# CITY OF ALBUQUERQUE

September 26, 2023

**Re: Take 5 Oil Change**  
**2151 Gibson Blvd. SE**  
**Traffic Circulation Layout**  
Engineer's Stamp 08-28-23 (M15-D021E)

DESIGN REVIEW COMMITTEE	CITY ENGINEER APPROVAL	ZONE MAP NO. M-15 & L-15
		CITY PROJECT NO.
		SHEET NO. C1.3

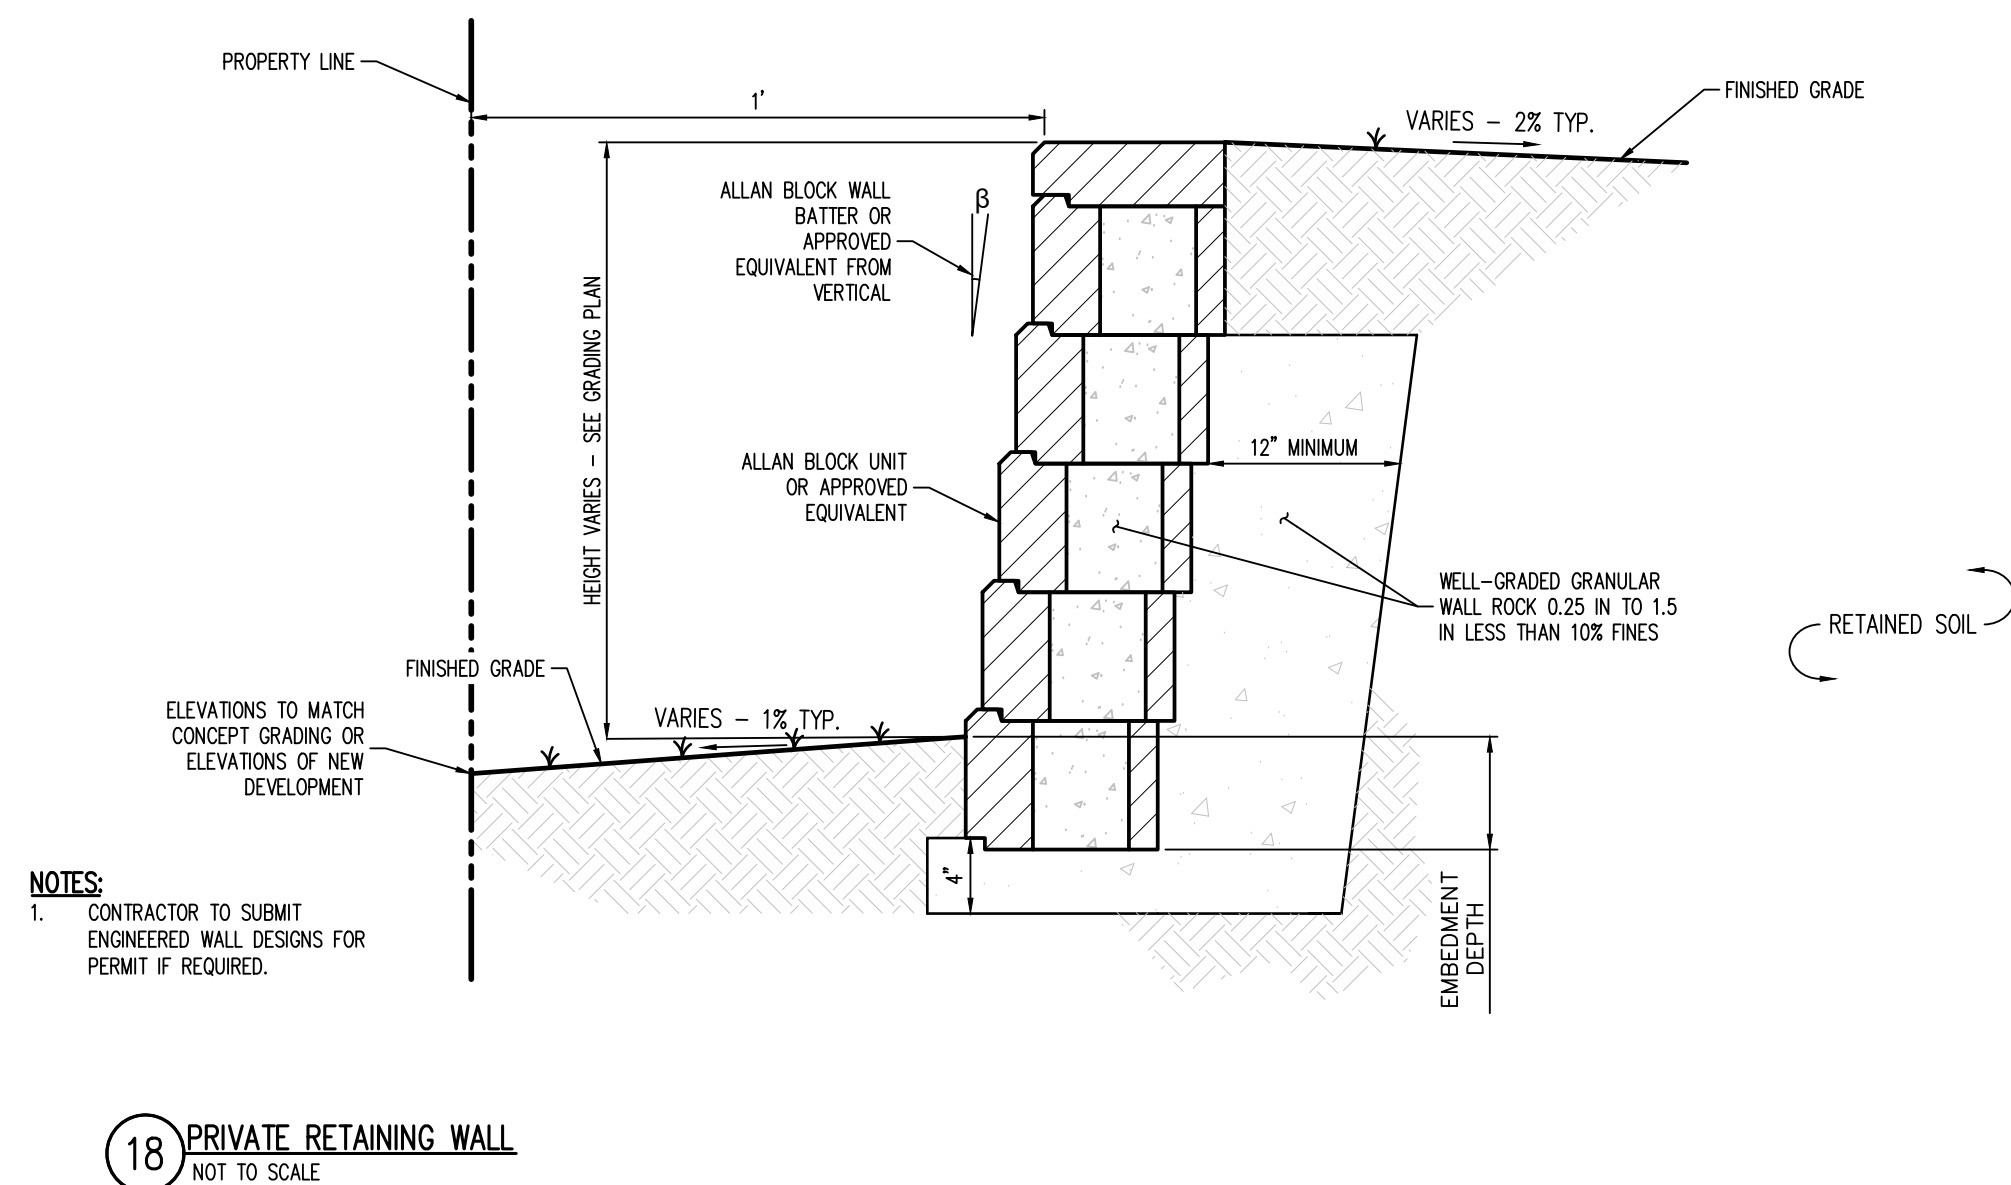
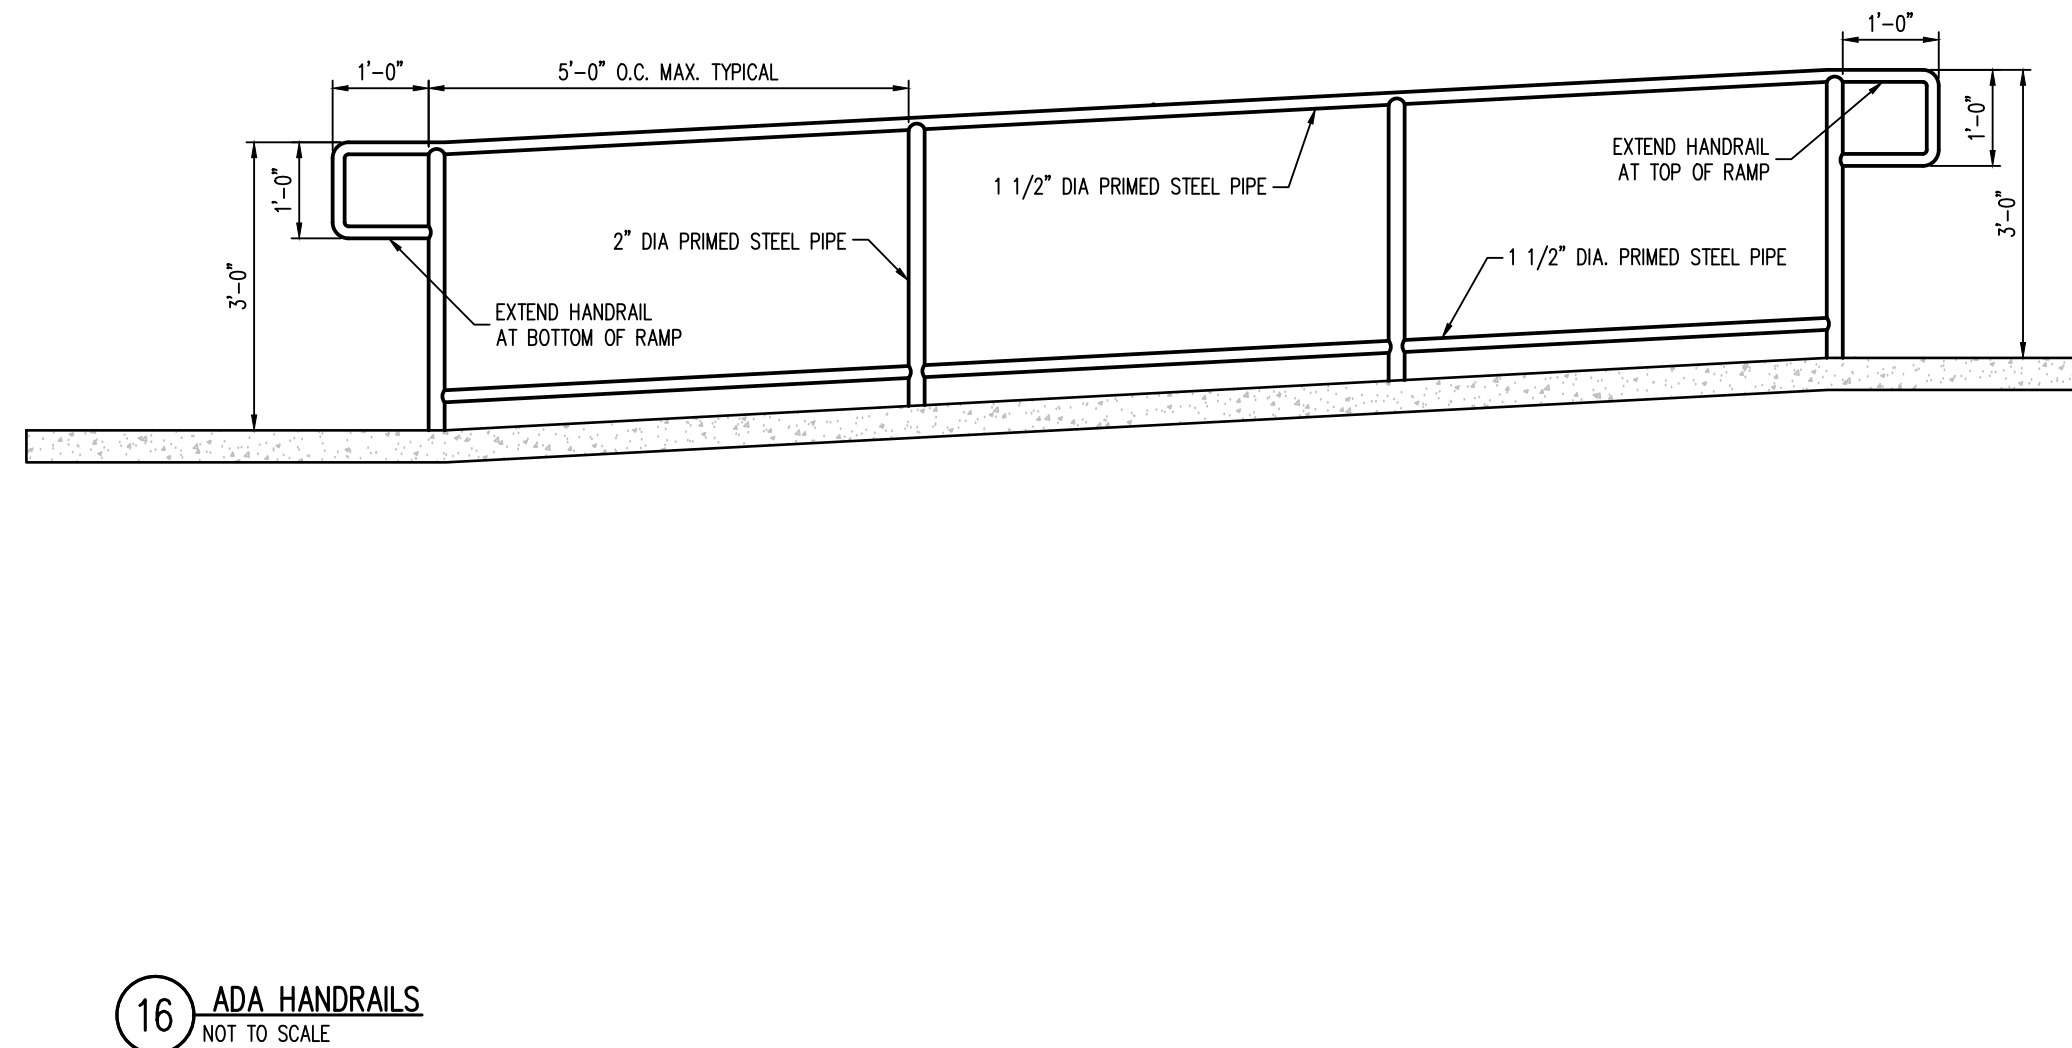
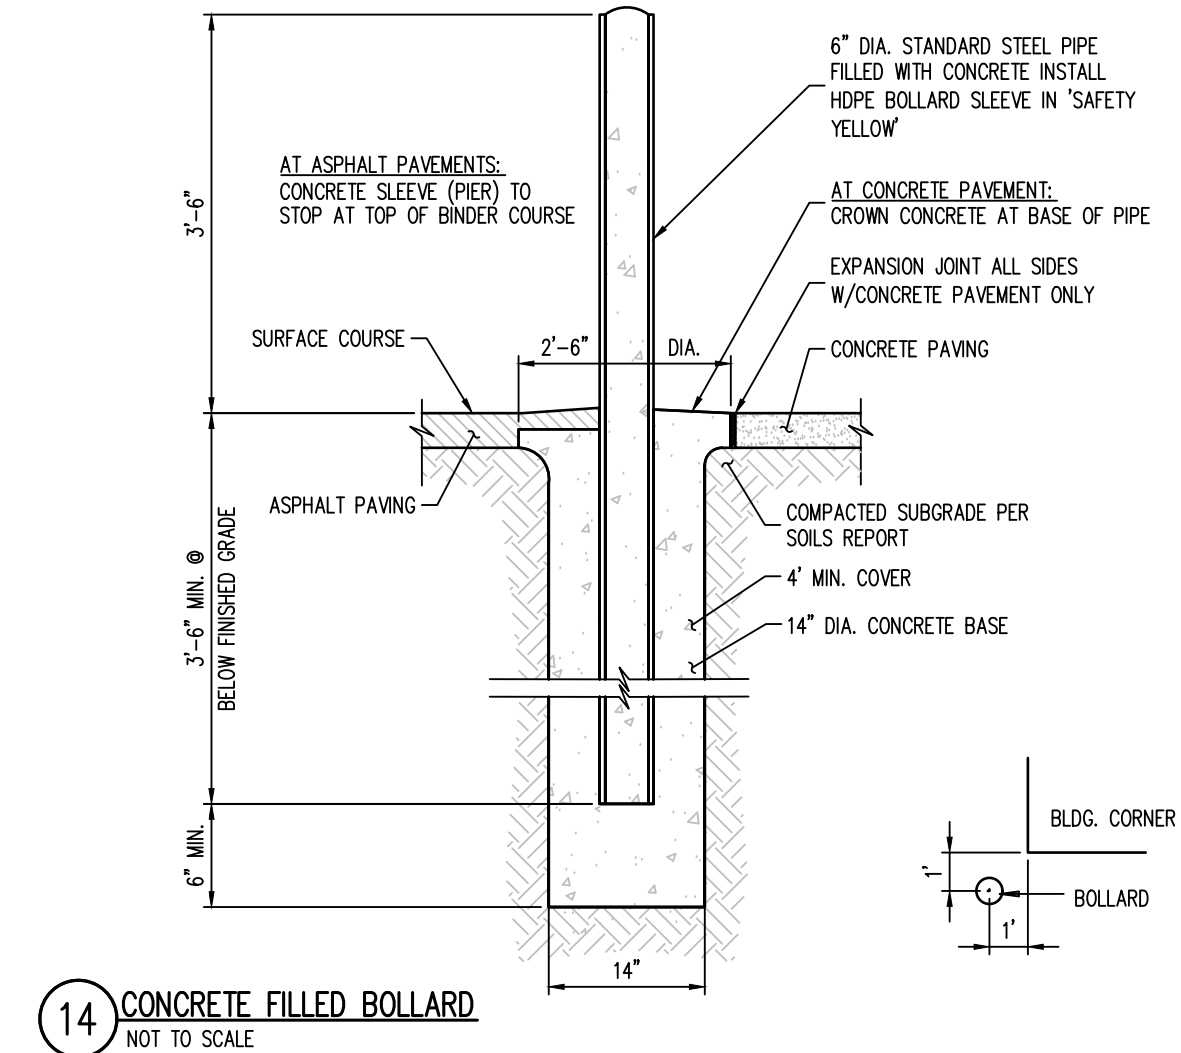
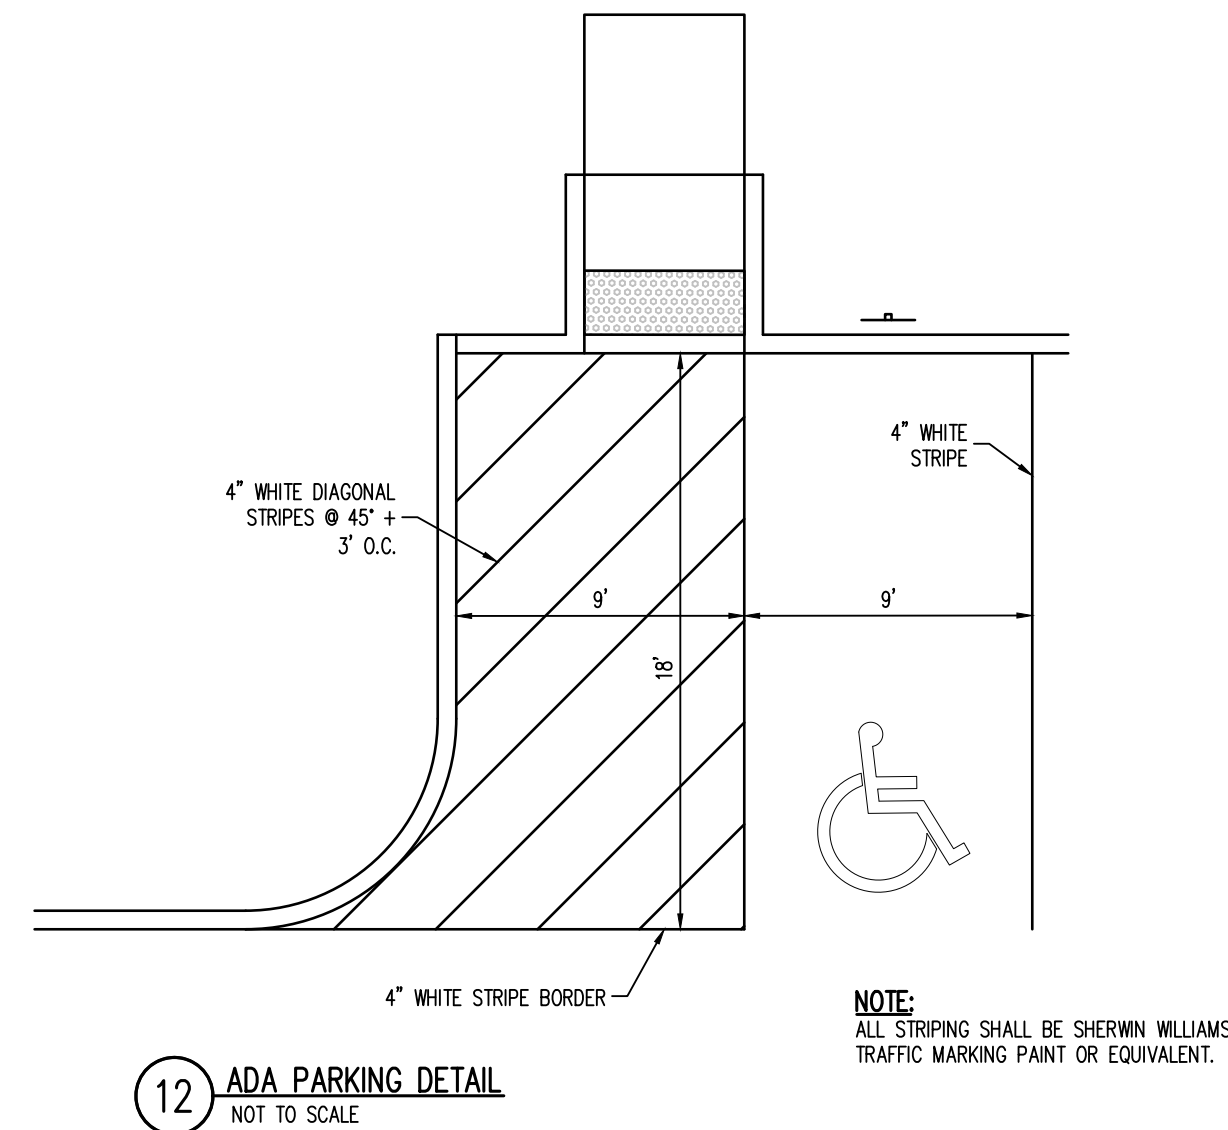
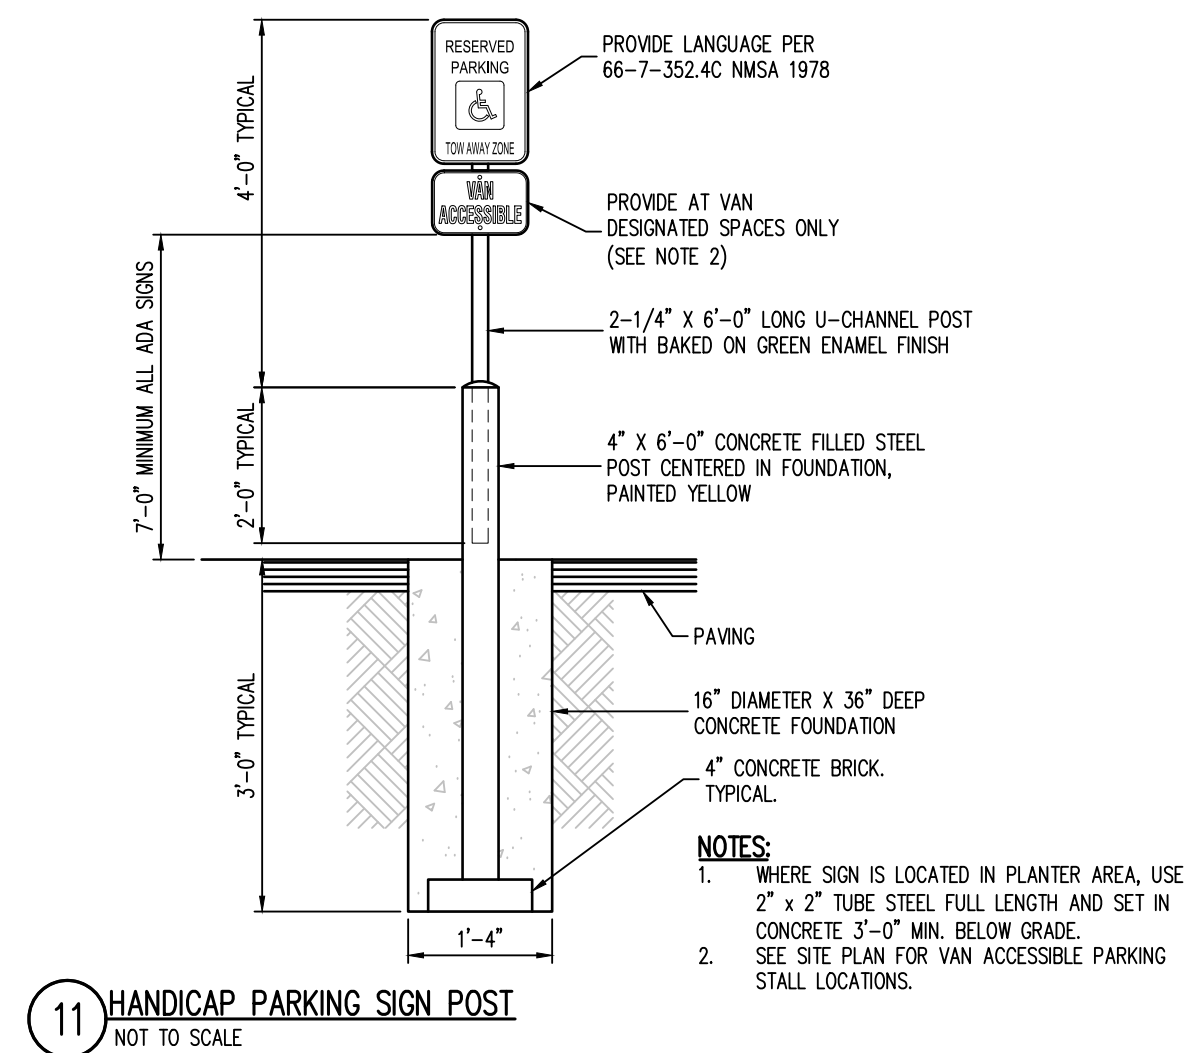
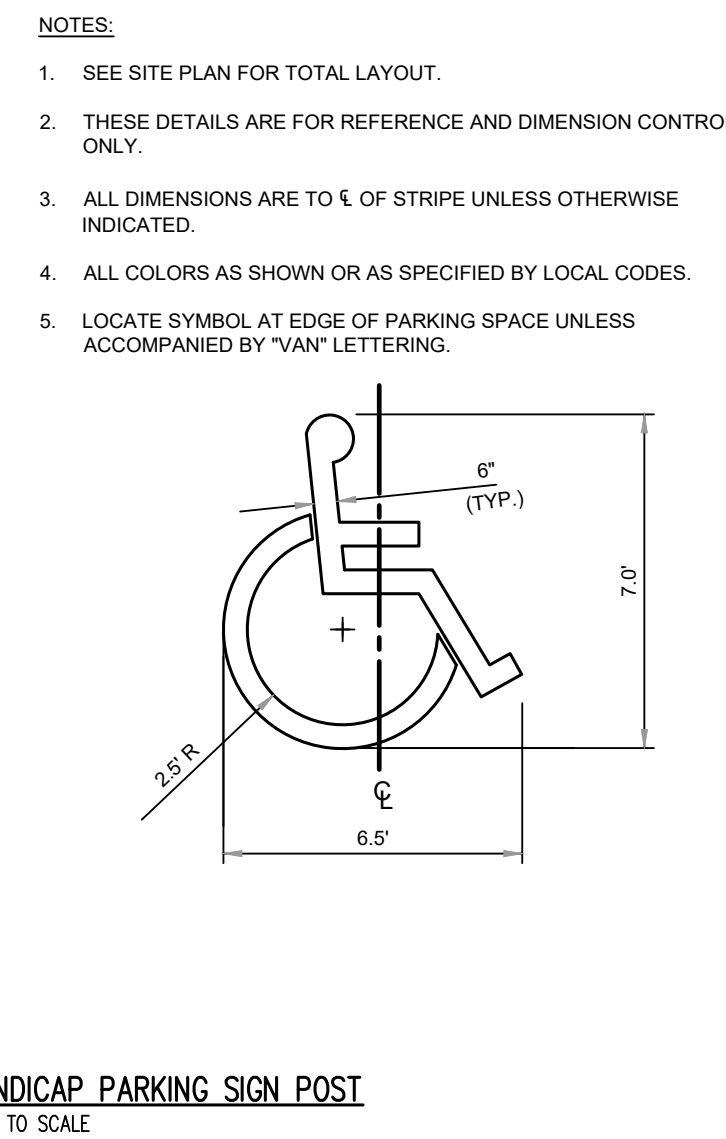
3. Per the DPM, the minimum two-way traffic drive aisle width should be 22 ft.
4. Please provide shared access and shared drive aisle agreement.
5. Sheet C1.4 shows an ADA handrails details. Please clarify the location of the proposed handrails.
